## Application for a Non-Material Amendment Following a Grant of Planning Permission

Land to r/o 21/21A Hatherleigh Road

Erection of two storey, two-bed dwelling with associated parking and amenity space provision, including demolition of existing garages at land to rear of 21 & 21A Hatherleigh Road.

41627/APP/2022/2128

South-East Elevation.

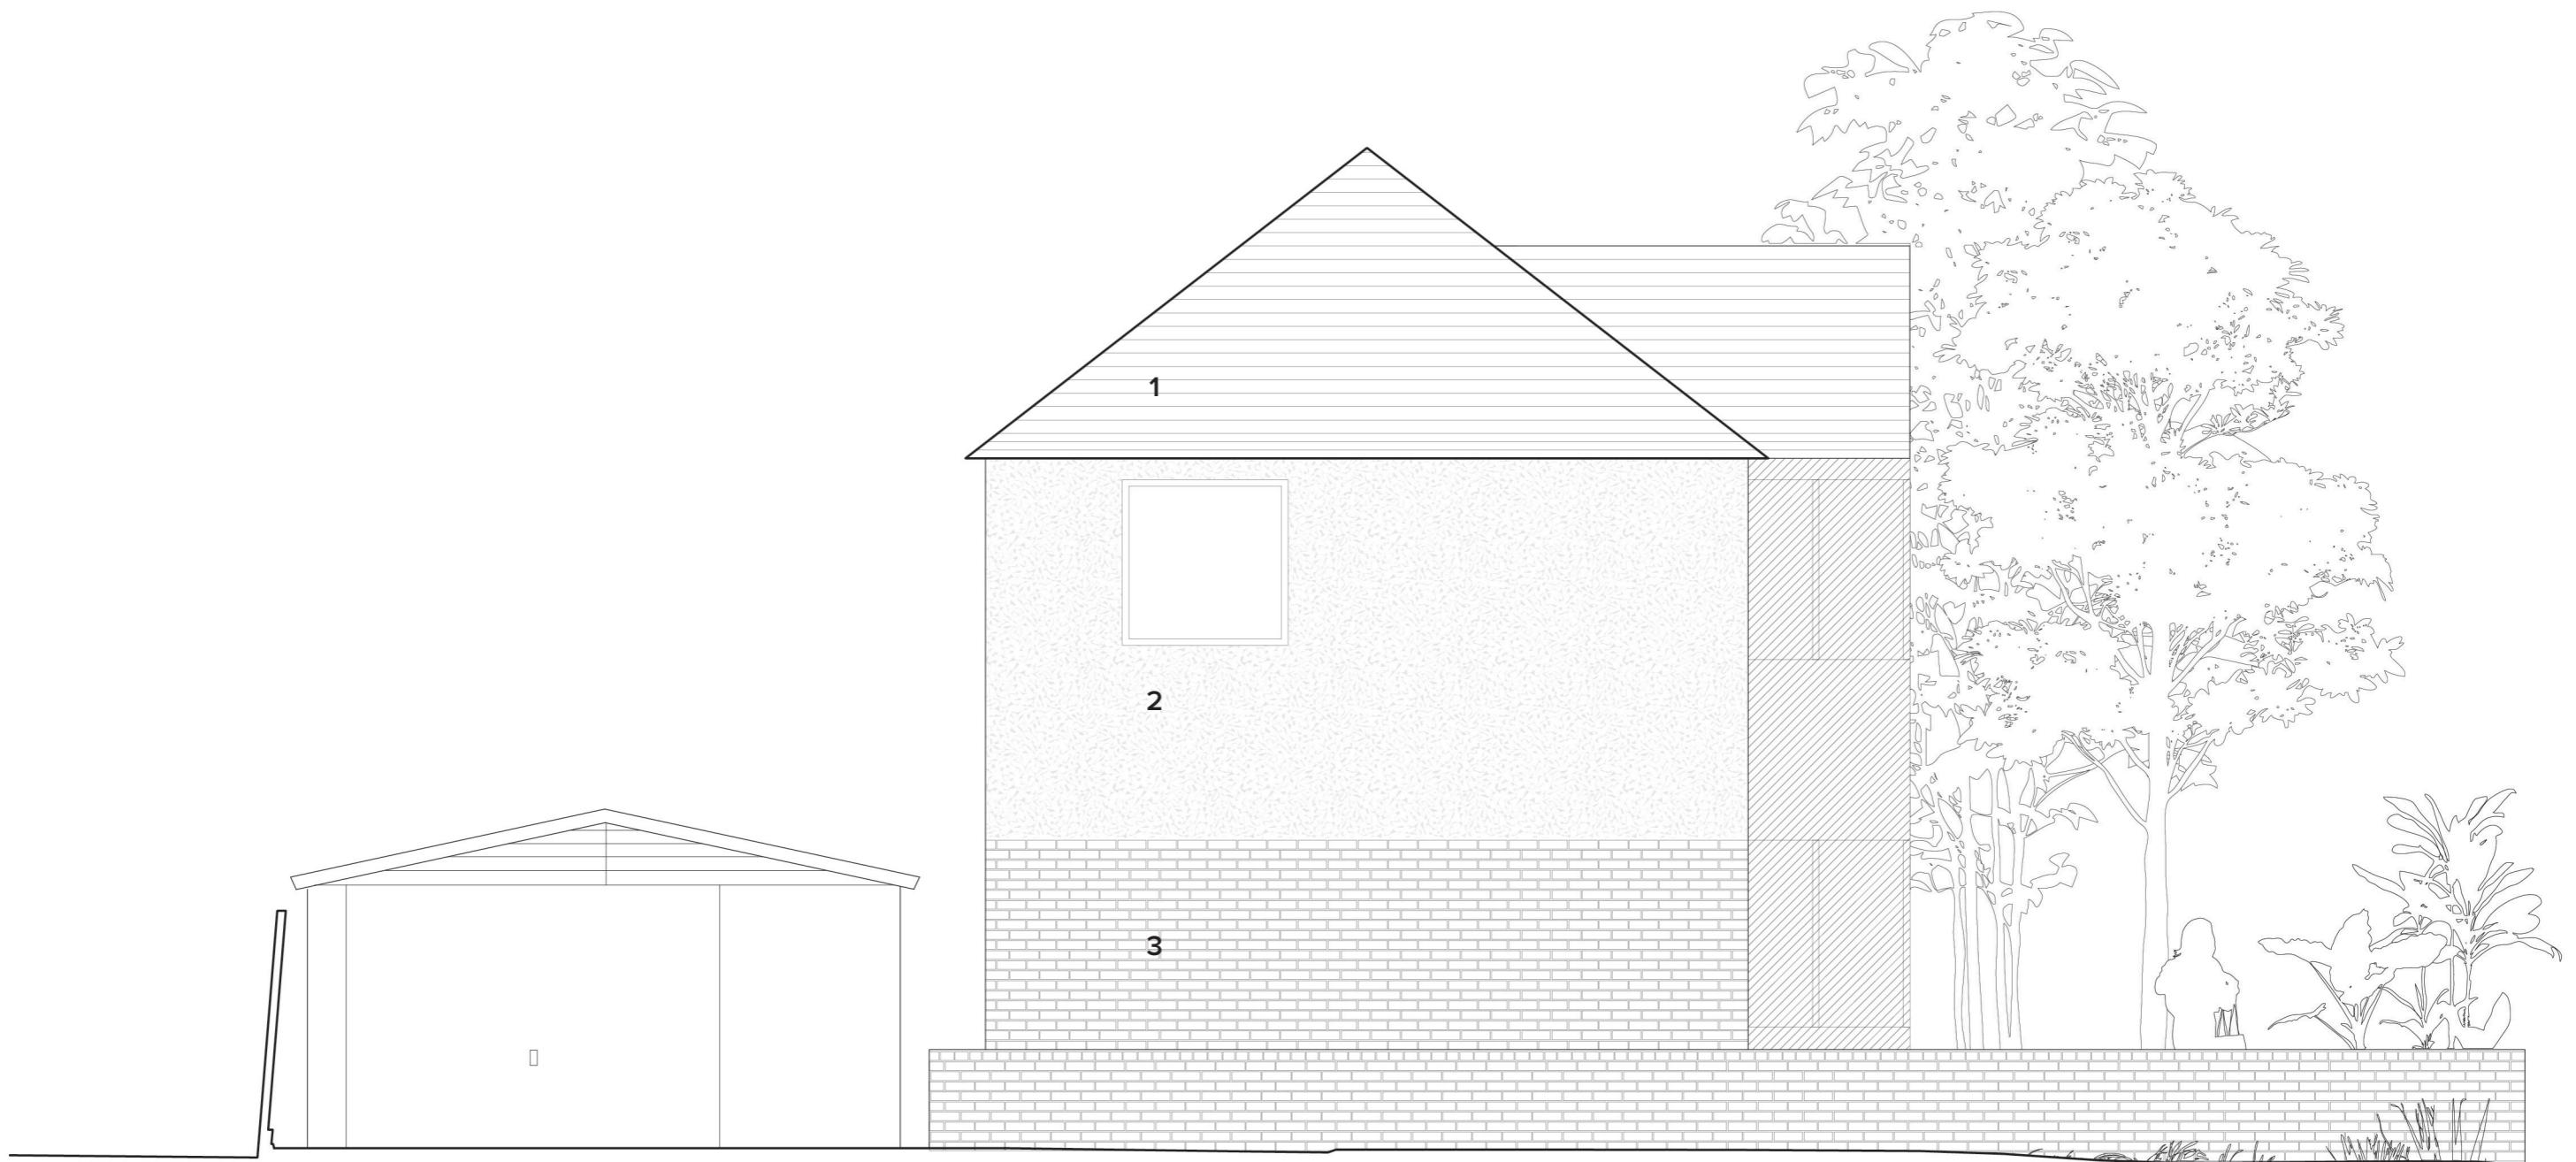
Brick extended to all ground floor walls as opposed to front elevation only.

Minor amendment to first floor window proportions in relation to structural design & building regulations compliance.

Visual improvement of extending brick to all four elevations and setting a consistent datum on elevations.

First floor windows need to avoid clash with structure and achieve minimum 800mm from finished floor level to comply with regulations.
